POST EPC MEMORANDUM

RE: PR-2022-007999 SI-2023-01621 – Site Plan – EPC_336 Woodward Rd. SE

The applicant for the Site Plan at 336 Woodward Rd. SE has worked with Staff to fulfill post EPC requirements to meet Conditions of Approval, 1-8, for SI-2023-01621. See EPC Notice of Decision (NOD) dated 11/16/2023.

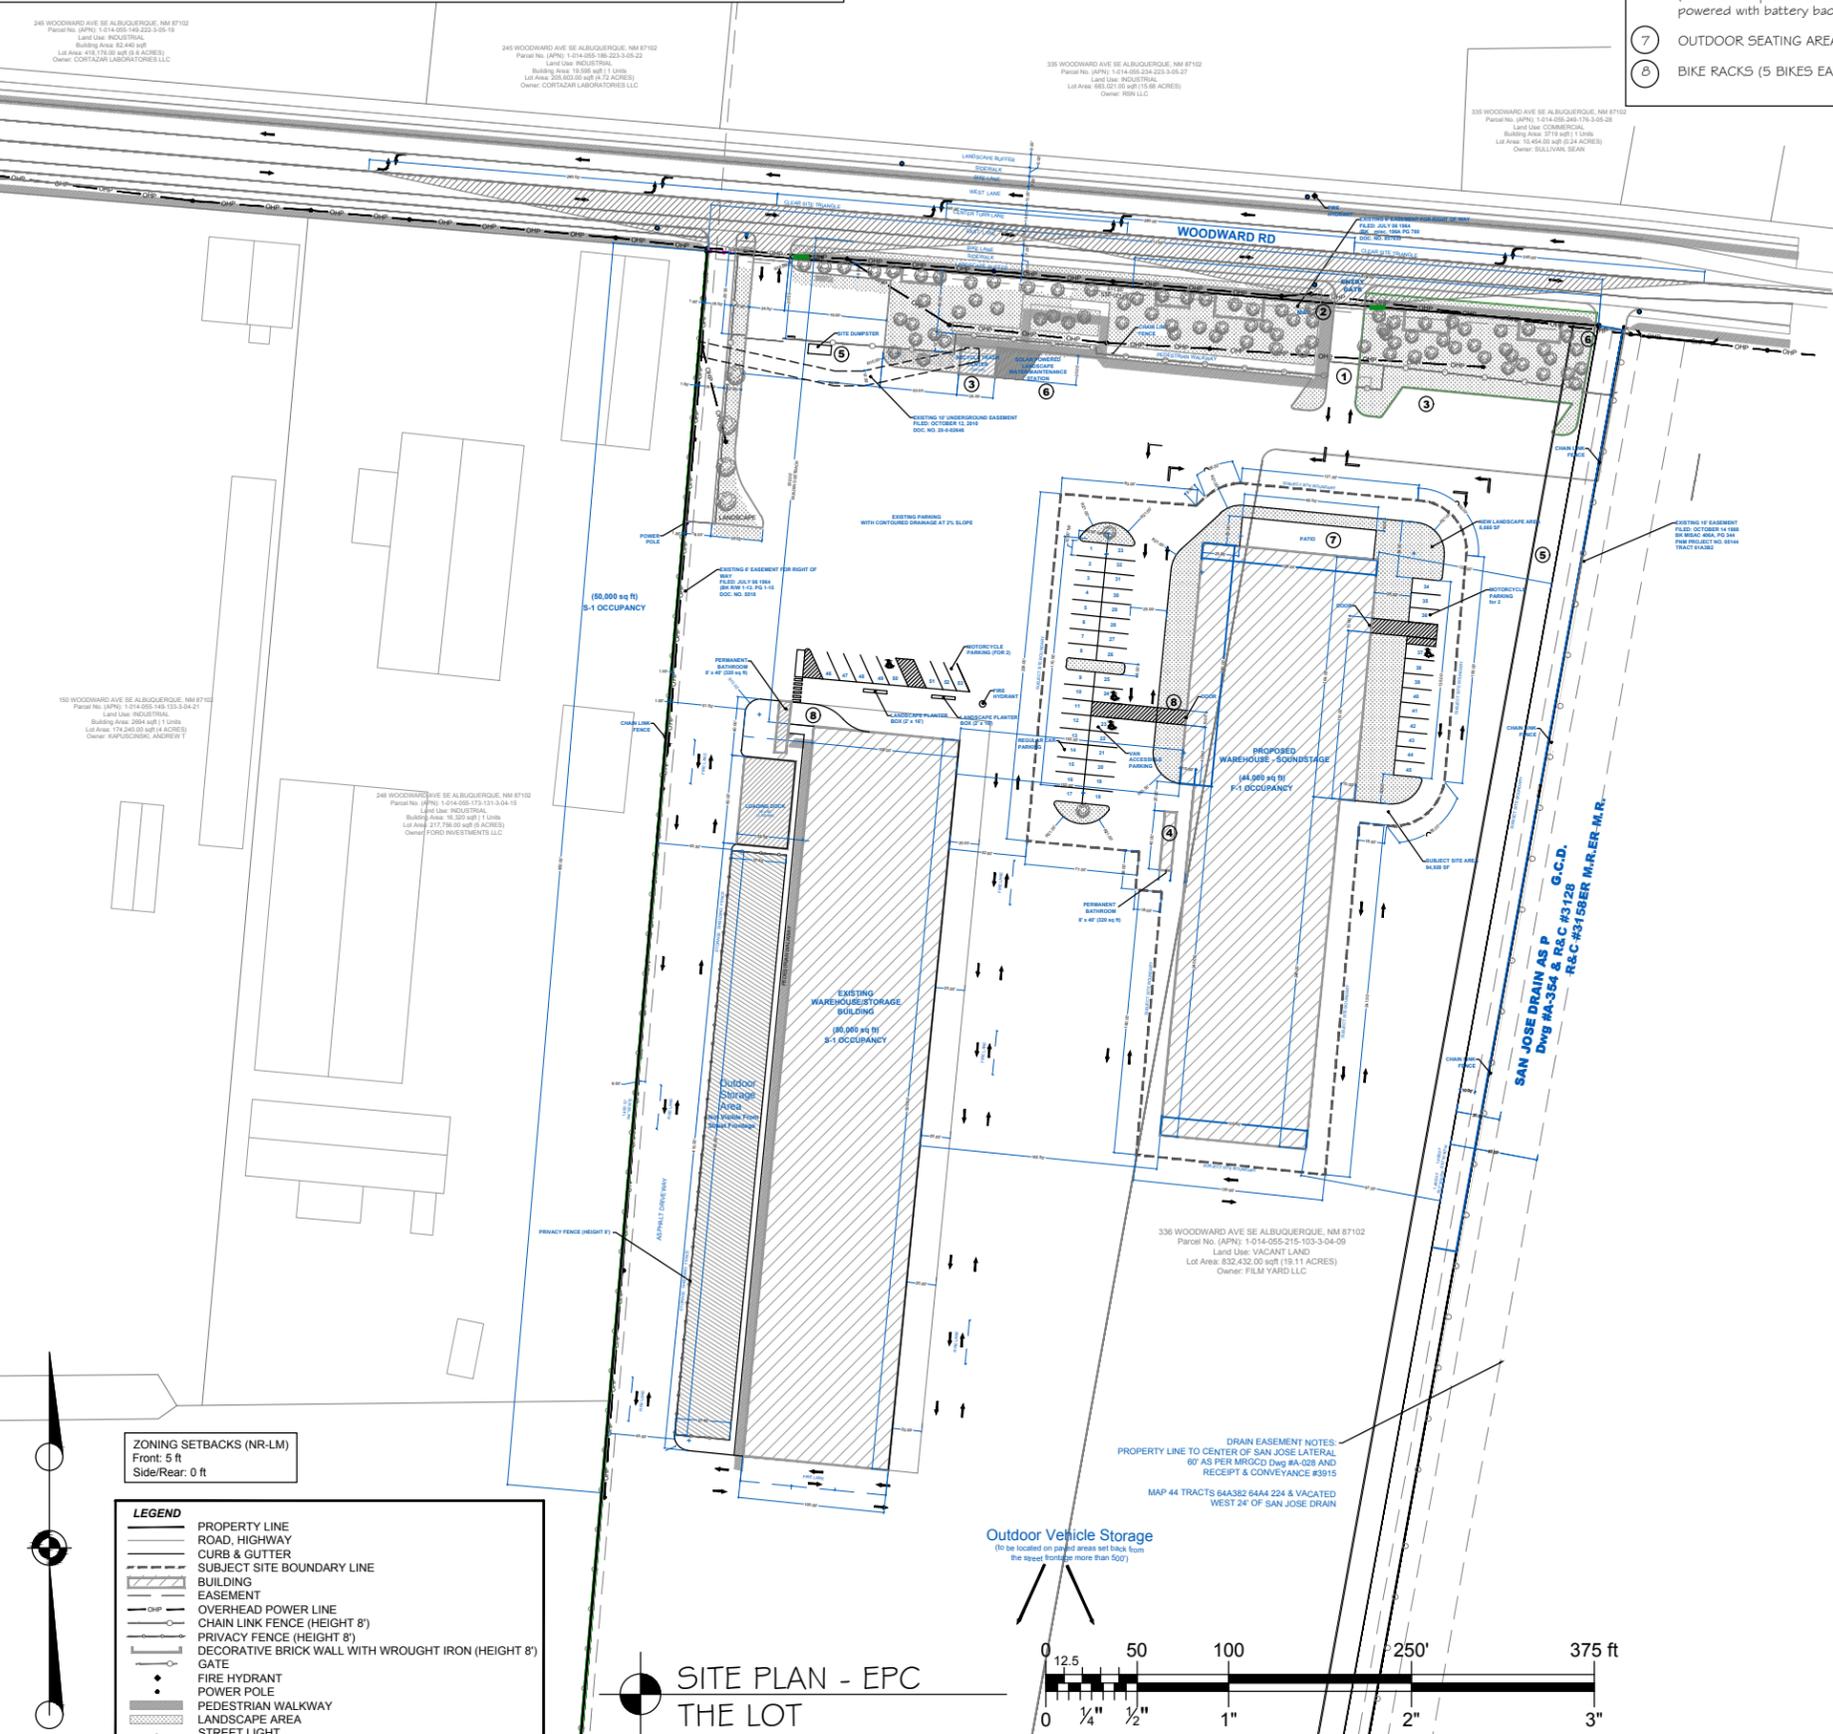
1. Approximately seven additional parking spaces have been added to the revised Site Plan (Sheet #1).
 - a. The applicant has stated that the TCL only requires seven spaces and they added some extra spaces just for convenience's sake and not any change in use.

2. The Keyed Notes have been revised slightly in the updated Site Plan (Sheet #1). A Keyed Note (2) has been added, indicated a mail box. Keyed Note 5 (Site dumpsters) appears to not be depicted on the revised Site Plan, though the dumpster appears to be in the same location as the Site Plan that was approved by the EPC. Keyed Notes indicated a landscaped green belt and block wall (Notes 7 and 8 in the EPC) approved Site Plan have been eliminated.

5. "Site Plan Notes" have been added to the revised Site Plan. Most of these notes indicate compliance with the conditions stated in the 11/16/23 NOD. However, these notes currently include an error stating that the site's zoning is CR-LM. This is incorrect. The site's zoning is NR-LM, which is shown on the EPC approved Site Plan.

- a. Regarding 2-5: The changes to keyed notes and general notes are all for clarification purposes and do not depict any changes to the site plan layout or changes to the EPC approves uses and site specifics.
